KITTITAS COUNTY

MEMORANDUM

TO: All Staff
FROM: Public Works Plan Review Team
DATE: August 15, 2024
SUBJECT: SP-24-00010 Fahlgren

FAHLGREN SHORT PLAT PART OF SECTION 5, T. 17 N., R. 18 E., W.M. KITITAS COUNTY, WASHINGTON

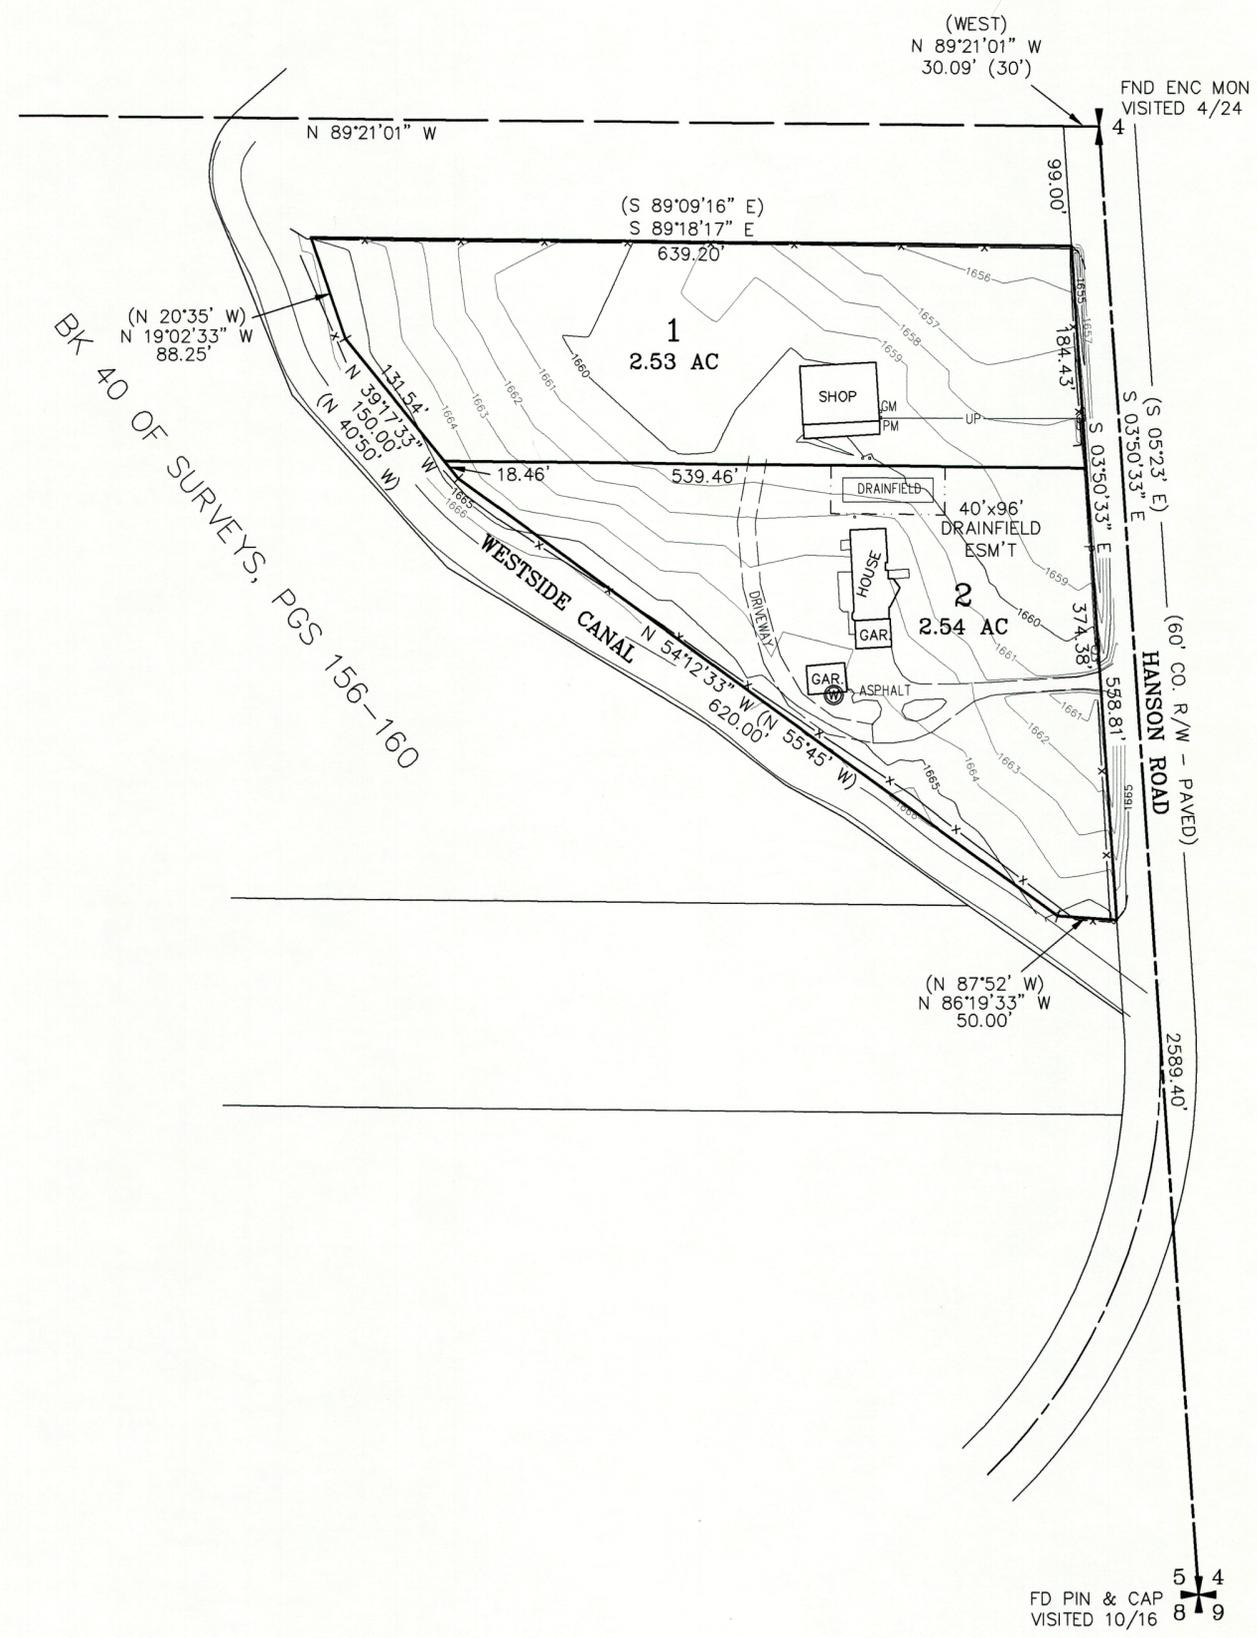
ACCESS	<ol style="list-style-type: none">1. Access spacing on this section of Hanson Road is 300 feet. A direct access to Hanson Road for this newly created parcel is not permitted. A shared access easement is required. Or applicant can apply for a variance prior to final short plat to allow direct access to Hanson Road.2. An approved access permit shall be required from the Kittitas County Department of Public Works prior to creating any new driveway access or altering an existing access.3. Maintenance of driveway approaches shall be the responsibility of the owner whose property they serve. The County will not maintain accesses.4. Any further subdivision or lots to be served by proposed access may result in further access requirements. See Kittitas County Road Standards.5. In addition to the above-mentioned conditions, all applicable Kittitas County Road Standards apply to this proposal. Access is not guaranteed to any existing or created parcel on this application. (JS) <p>OF NOTE: Existing address of 1421 Hanson Road to be assigned to parcel 2 upon recording of the short plat.</p>

ENGINEERING	Except as exempted in KCC 14.05.060, no grading or filling upon a site involving more than one hundred (100) cubic yards shall be performed without a grading permit from the County Engineer or Public Works designee (KCC 14.05.050). An application for grading in excess of five hundred (500) cubic yards shall be accompanied by an engineered grading plan (KCC 14.05.080). (CP)
SURVEY	<p>The following review applies to the Prelim Short Plat only. Additional comments may address final submittal.</p> <ol style="list-style-type: none">1. Submittal does not meet the requirements of WAC:332-130-145 Topographic elements on maps.2. Proposed Lot 1 and Lot 2 do not appear to meet dimensional requirements per KCC 17.29.090. <p>FOR FINAL</p>

<p>At a minimum, property corners will need to be set and shown on the map for the new division line.</p> <p>Please identify if the drain field easement is herein created, existing, or to be established via a separate document.</p> <p>OF NOTE Lot closures were not reviewed as part of this submittal. Given the simplistic nature of the division, lot closures are not required. Title report was reviewed as part of this submittal. Ownership and legal description is fine. (JT)</p>
TRANSPORTATION CONCURRENCY	No transportation concurrency requirement for this project. (KAH)
FLOOD	Parcel #178333 is not located in a FEMA identified special flood hazard area (100-year floodplain). A floodplain development permit is not required for the project. (SC)
WATER MITIGATION/METERING	<p>The following comments outline the requirements for legal availability of water and metering for the proposed short plat:</p> <p>The applicant must provide legal water availability for all new uses on the proposed lots of this project, which can be provided through mitigation certificates. Prior to final plat approval and recording, the following conditions shall be met:</p> <p>In accordance with KCC Chapter 13.35.027, the applicant shall provide one of the following documents before final plat approval:</p> <ol style="list-style-type: none"> 1. A letter from a water purveyor stating that the purveyor has adequate water rights and will provide the necessary water for the new use; 2. An adequate water right for the proposed new use; or 3. A certificate of water budget neutrality from the Department of Ecology or other adequate interest in water rights from a water bank. <p>All applicants for land divisions shall also submit information on "proximate parcels" held in "common ownership" as those terms are defined in WAC 173-539A-030 and otherwise demonstrate how the proposed new use will not violate RCW 90.44.050 as currently existing or hereafter amended.</p> <p>Failure to obtain mitigation before commencement of an activity requiring mitigation shall be a code violation subject to enforcement under Title 18 KCC.</p> <p>Final Plat Notes</p> <p>The following notes shall be placed on the face of the plat:</p>
